**April 6, 2005  
DRB Comments**

**PROJECT # 1003865**

**APPLICATION # 05-00521**

**RE: North Albuquerque Acres, Unit B/ minor plat**

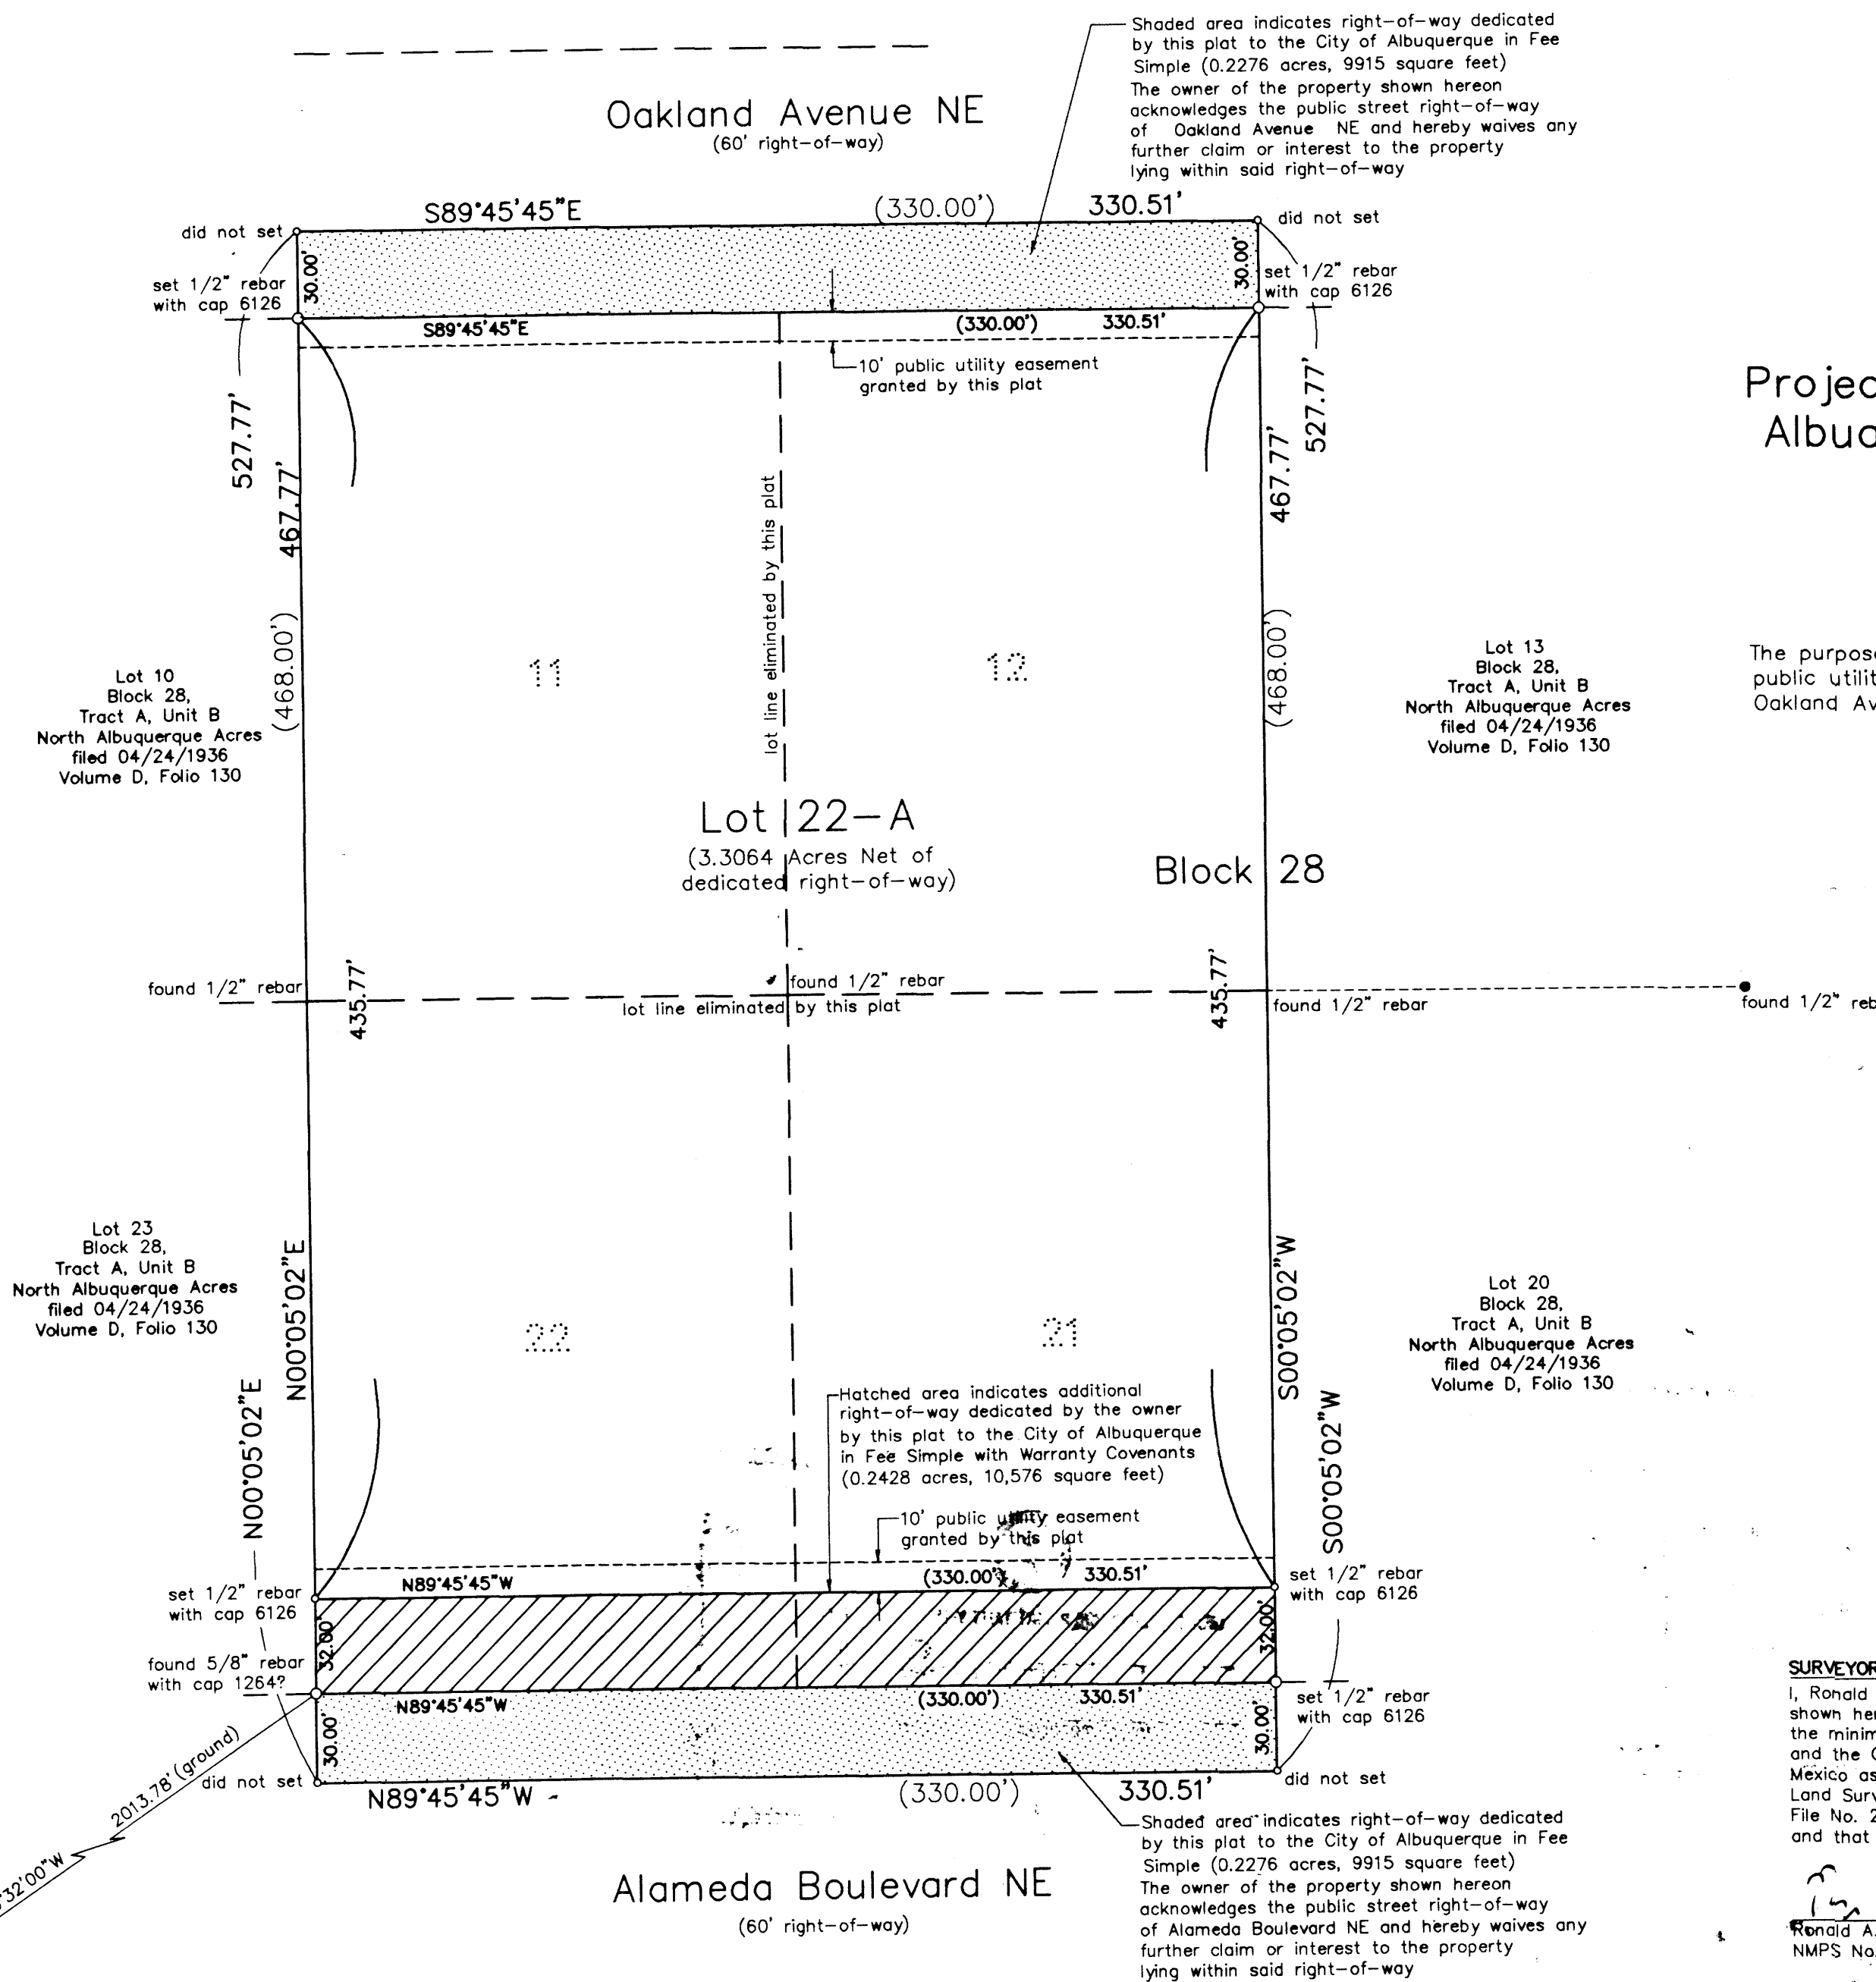
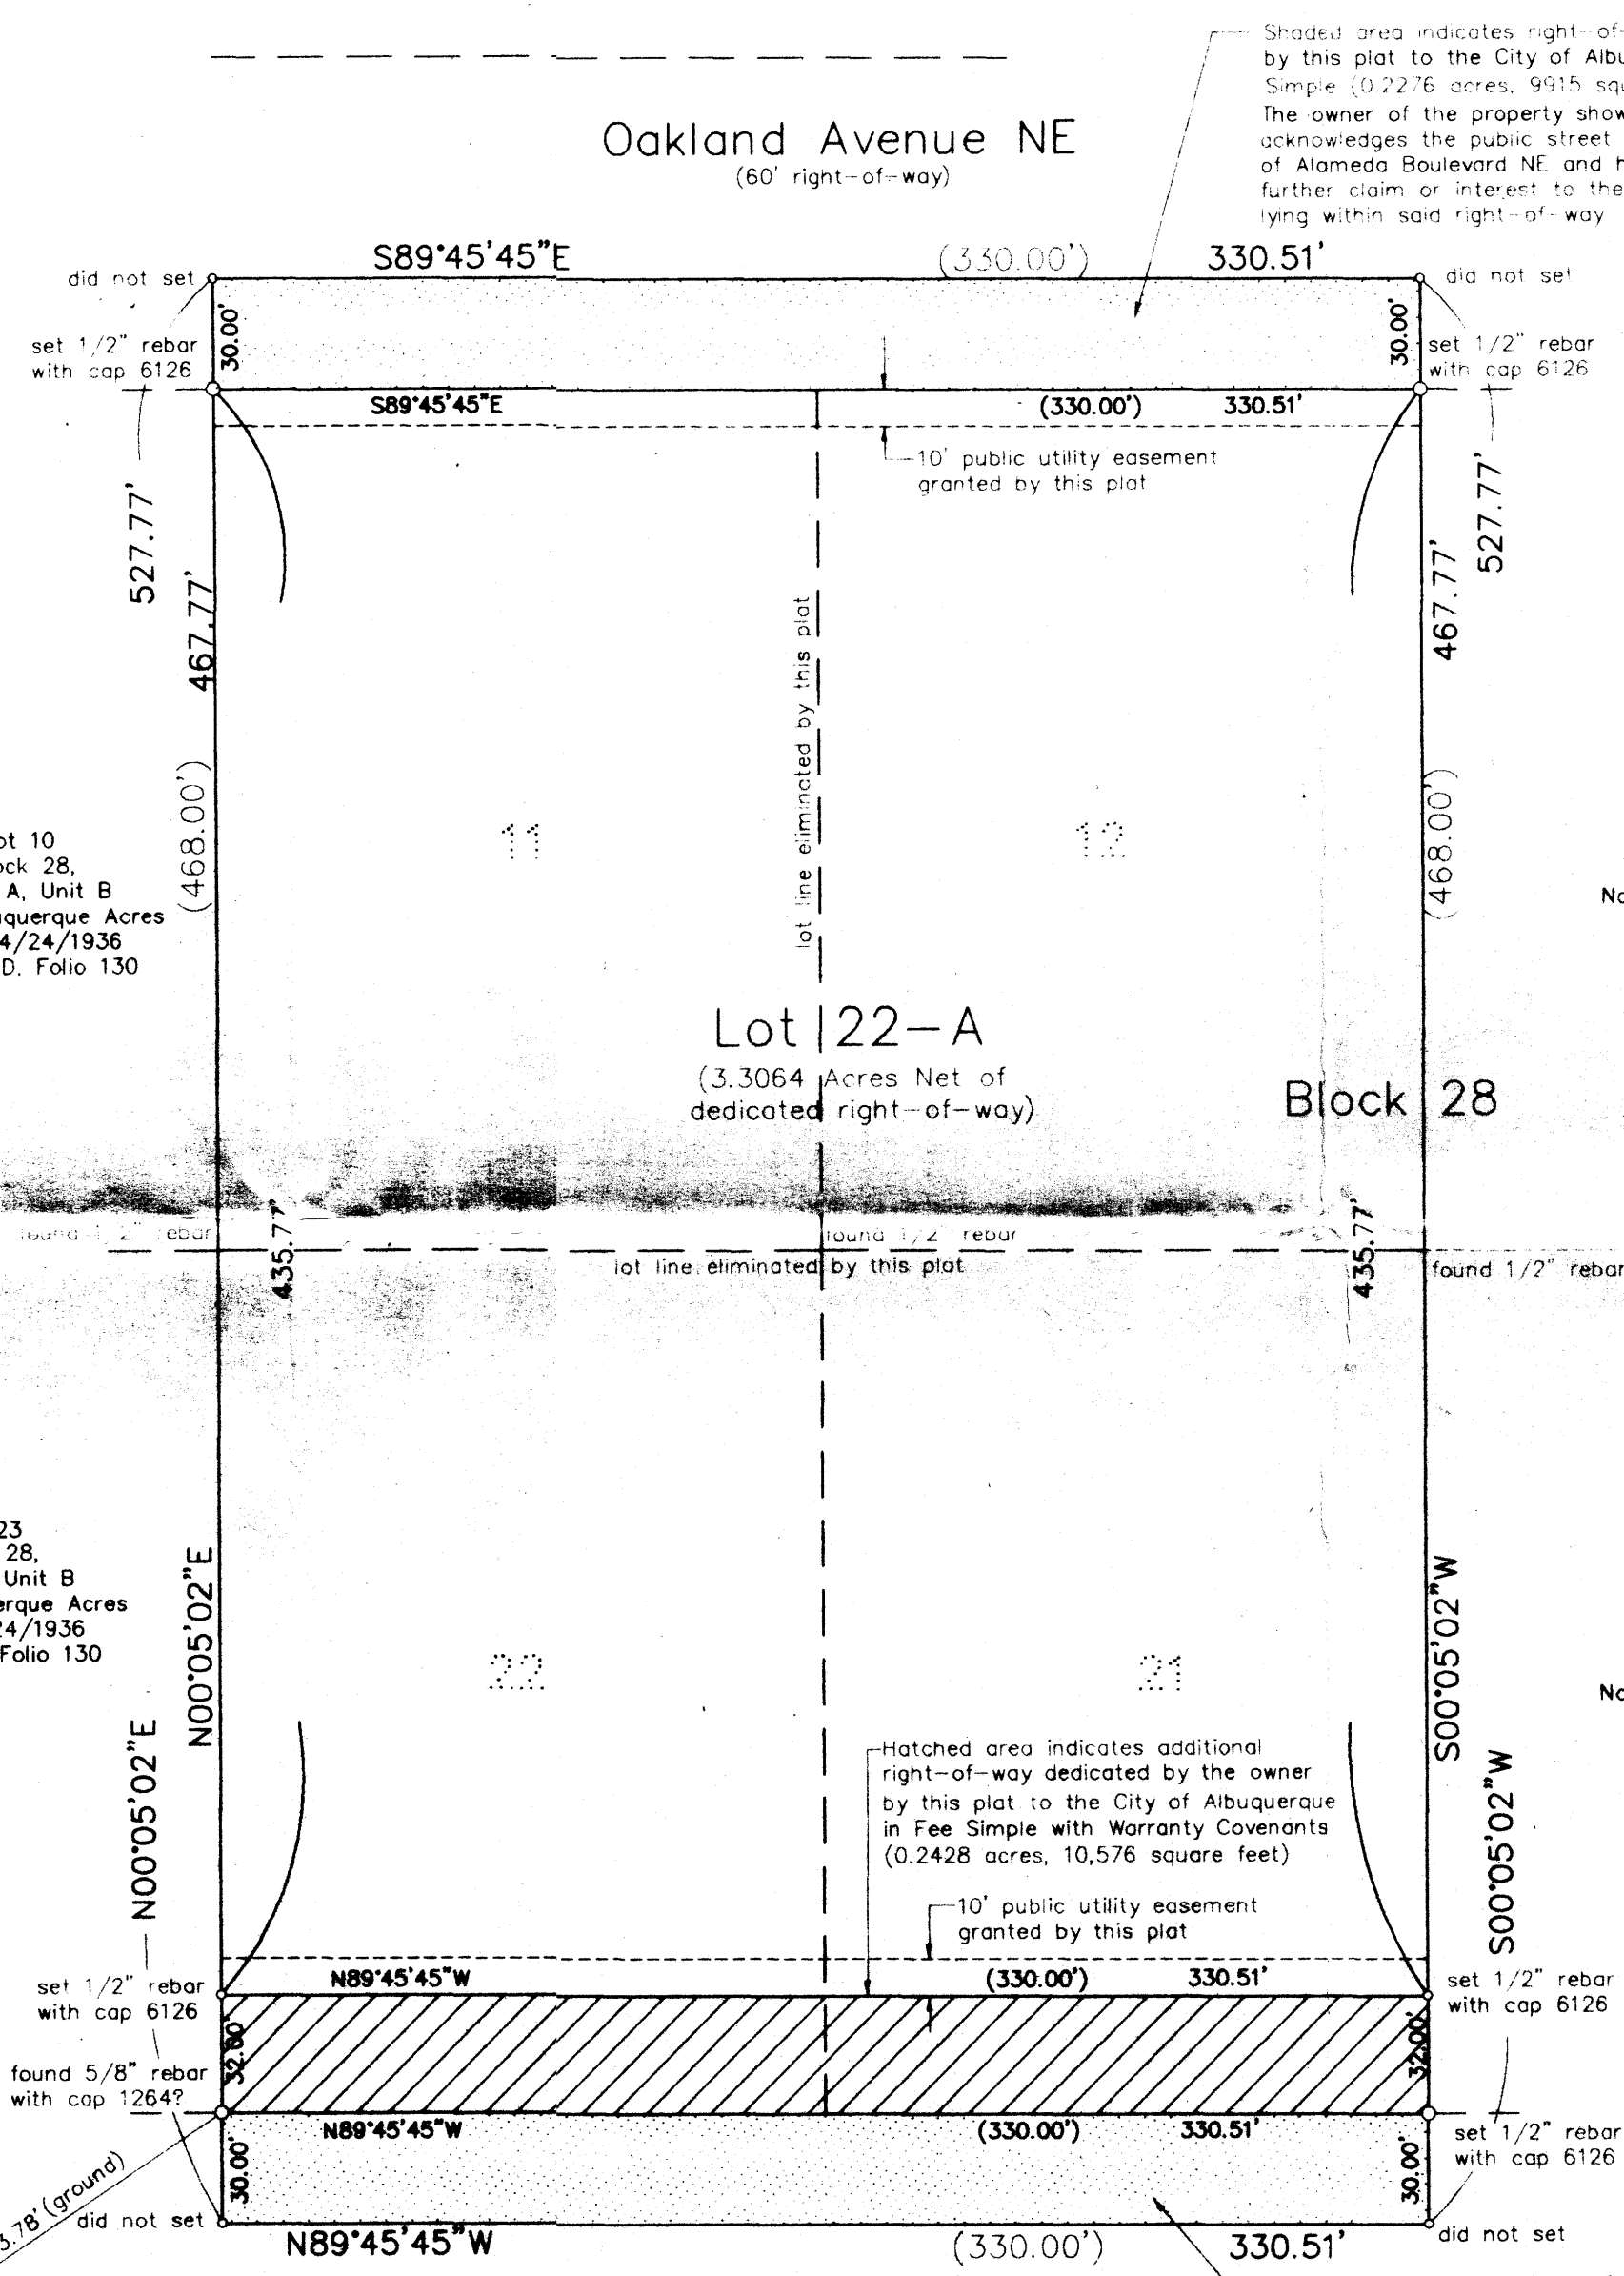
There are no objections to this request once the Site plan for Subdivision is corrected to match the plat with regard to lot size. Also, the Site Plan for Building permit was indefinitely deferred for the plat. The SPBP must be heard at DRB for final approval.
